Recommendation Report for Planning Permission for Works or Extension to a Dwelling

REF NO: FP/94/26/HH

LOCATION: 15 Manor Close
Felpham
PO22 7PN

PROPOSAL: Rear extension, enlarged dormer, internal remodelling and new windows and doors.

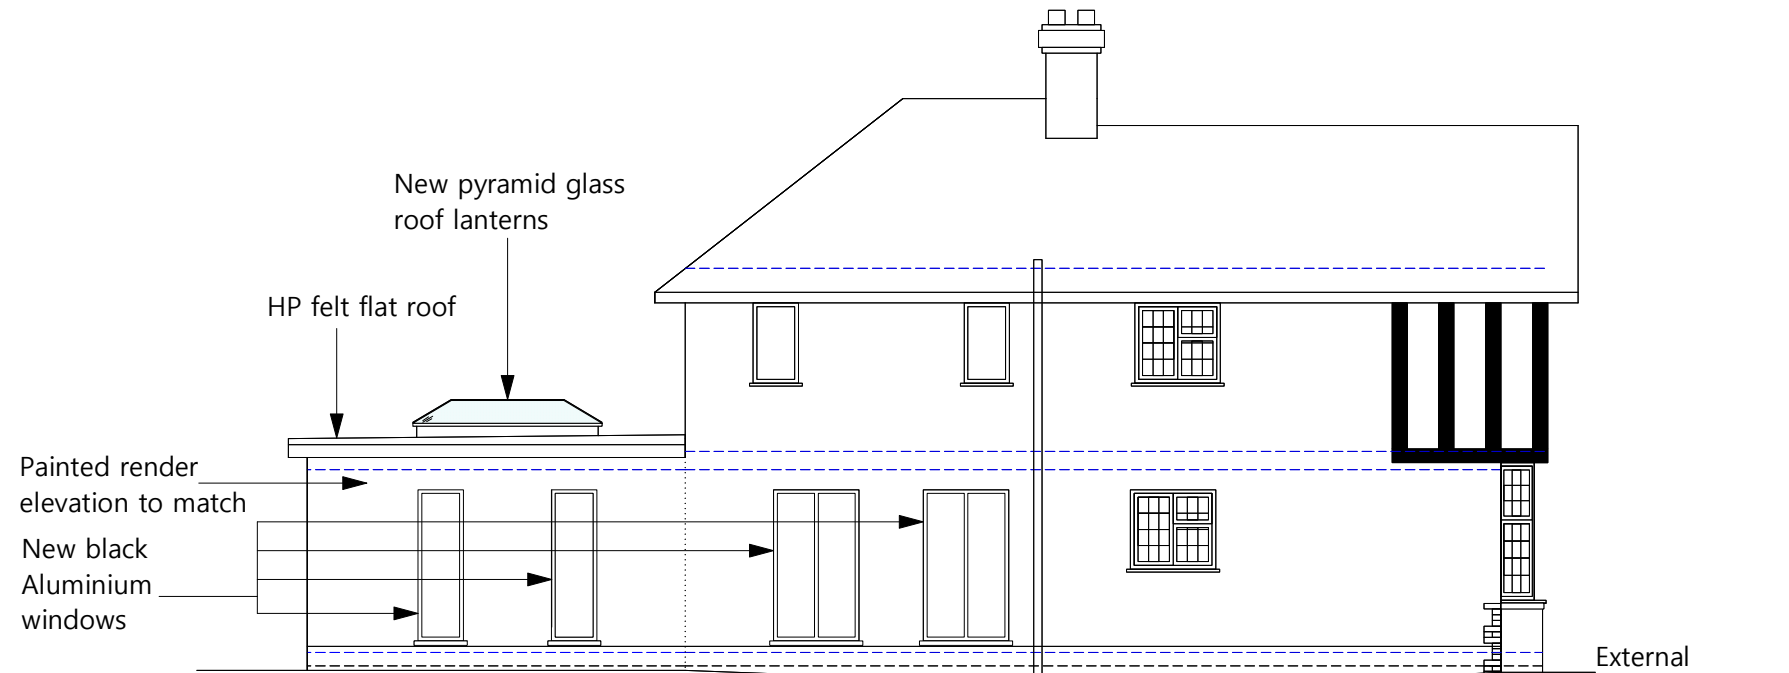
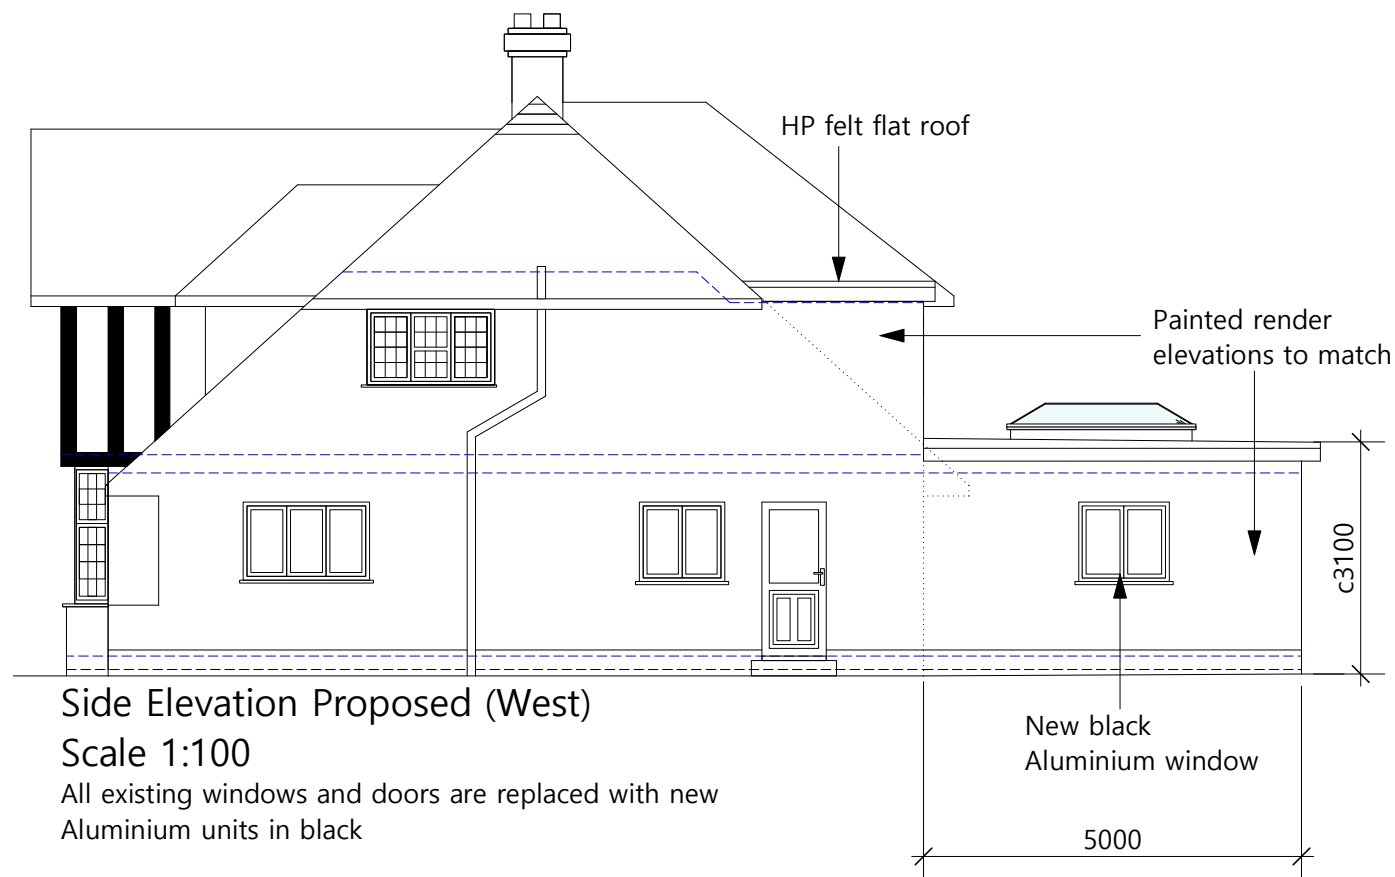
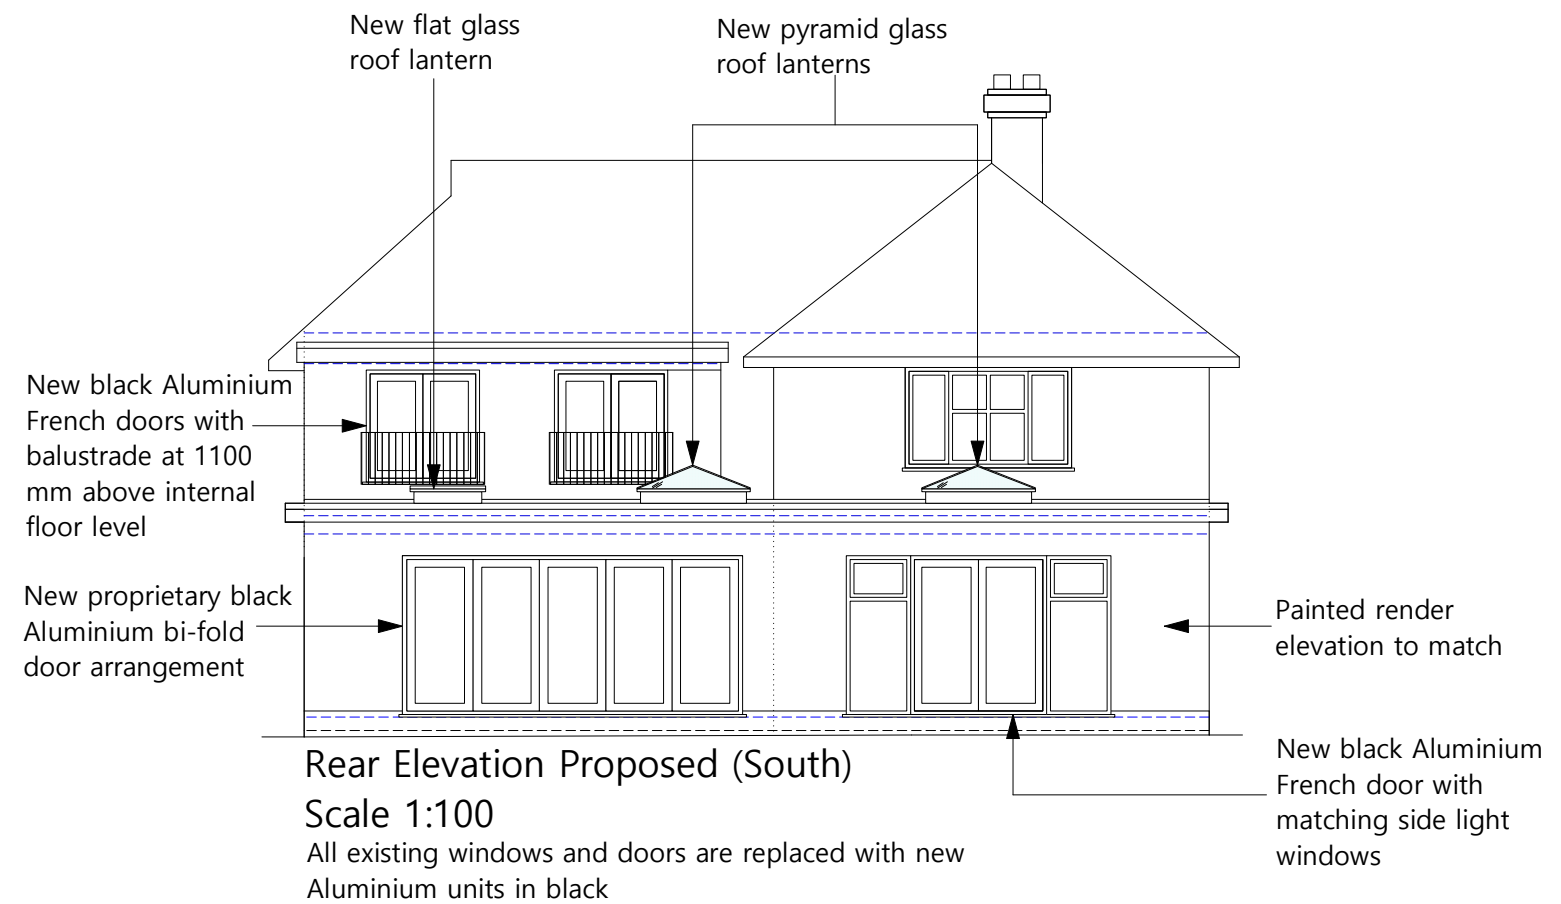
The extension would measure approximately 5m in depth and span the full width of the dwelling, measuring approximately 12m in width. It would incorporate a flat roof with a maximum height of approximately 3.5m, including the roof lanterns. External materials would comprise render to match the existing dwelling, ensuring a cohesive appearance in accordance with the Arun Design Guide (ADG).

The extension would incorporate bifold doors, French doors with glazed side panels, a two-pane window within the western side elevation, and two slim horizontal windows within the eastern side elevation. The flat roof would contain two pyramid roof lanterns and one flat glazed roof lantern. All new windows and doors would be finished in black aluminium.

Given its sitting to the rear, the extension would not be visible from the public realm. Whilst the depth would exceed the 3.3m guidance depth for single storey rear extensions outlined within the ADG, it would remain proportionate to the host dwelling and would be contained within a relatively large plot. Similar forms of development are evident within the surrounding area and, as such, the proposal would not appear out of character or result in harm to the appearance of the host dwelling or wider locality.

The proposal also includes the enlargement of an existing dormer within the rear (south) roof slope. The altered dormer would measure approximately 2.5m in depth and 5.5m in width, with a flat roof and a maximum height of approximately 2.1m. It would be constructed using materials that match the existing dwelling and would incorporate two French doors with a black aluminium balustrade.

The dormer would be relatively large and would not be a subservient addition within the roof slope. This would be contrary to ADG guidance which advises dormers should remain minor elements within the roof plane and generally avoid flat roofs, it would replace an already established built form. Given its position on the rear elevation, it would not be visible from the street scene and would not appear incongruous within its setting. The departure from the ADG would therefore be acceptable.

Alterations to fenestration are proposed, including the insertion of two horizontal two-pane windows within the existing eastern side elevation. Existing windows and doors throughout the dwelling would also be replaced with black aluminium units. Given the presence of similar dark-framed fenestration on neighbouring properties, these changes would integrate satisfactorily within the street scene and would not adversely affect the character or appearance of the dwelling or surrounding area.

The proposed ground-floor rear openings would be positioned broadly in line with the existing fenestration and would not introduce additional overlooking opportunities. New windows are proposed within both side elevations of the extension, alongside two additional windows within the existing eastern side elevation of the dwelling. As these elevations already contain openings and the proposed windows would be located at ground-floor level, they would not result in any materially greater degree of overlooking or loss of privacy than currently exists.

The enlarged dormer would incorporate larger glazed openings than existing. However, these would primarily overlook the rear garden and would replace existing windows serving the same outlook. Accordingly, these windows would not result in additional overlooking or loss of privacy.

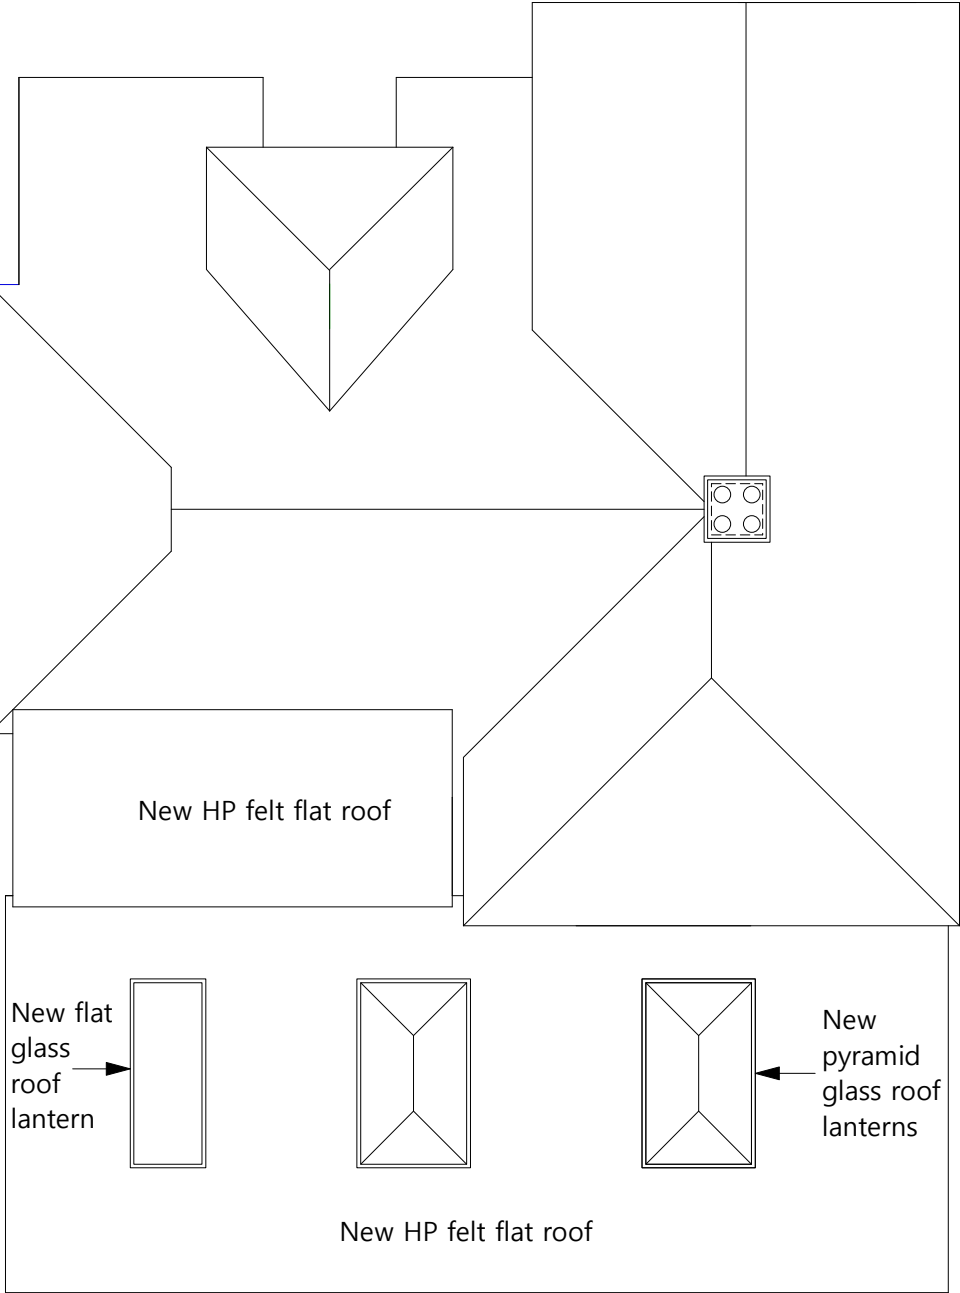
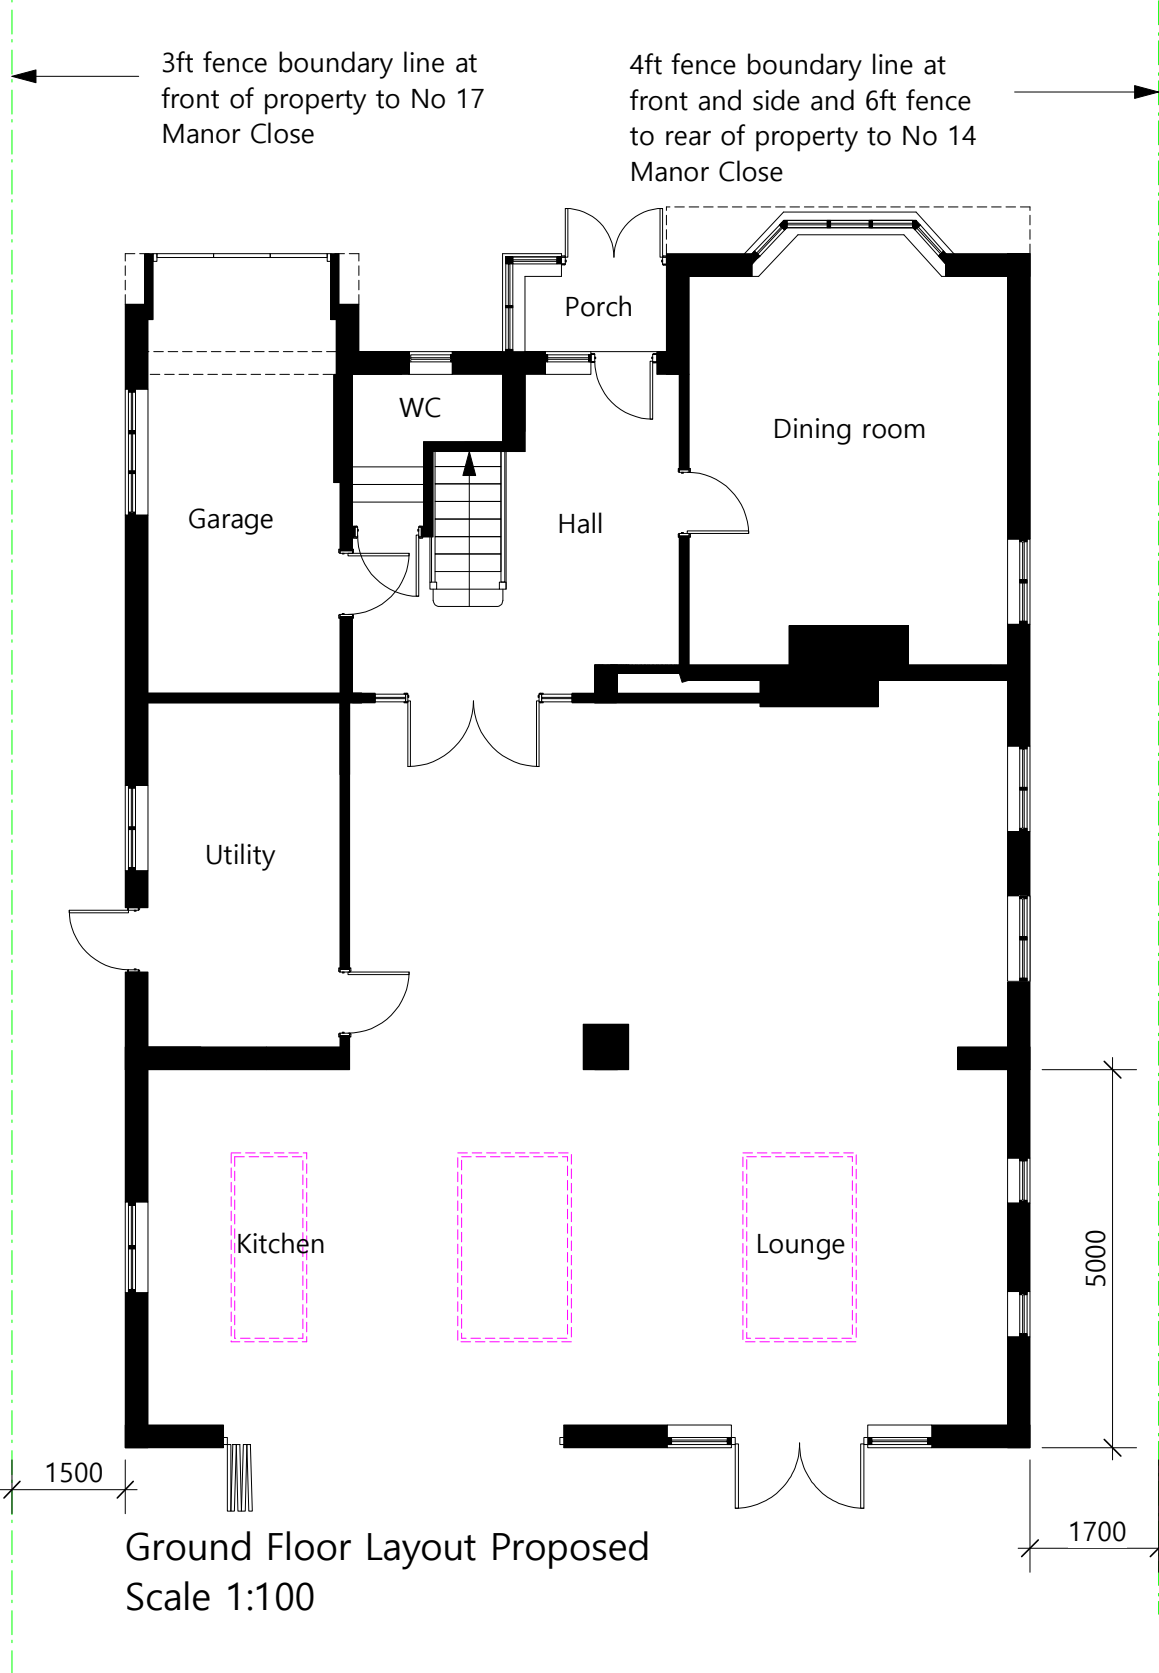
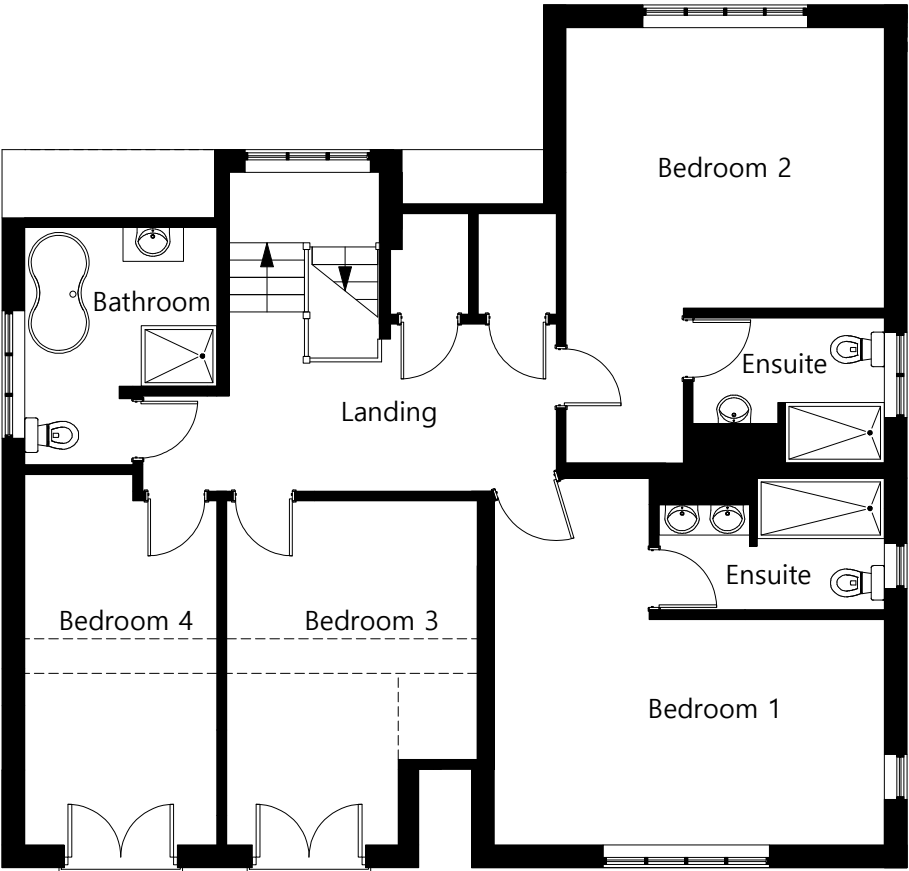
The proposed rear extension would be set in approximately 1.7m from the western and eastern side boundaries. It would be set back approximately 26m from the southern (rear) boundary. Due to its single-storey form, flat roof design and the separation distances involved, the development would not result in overbearing or overshadowing of neighbouring occupiers.

The proposed roof lanterns would be set within the flat roof and, by virtue of their design and orientation, would not afford direct views towards neighbouring properties.
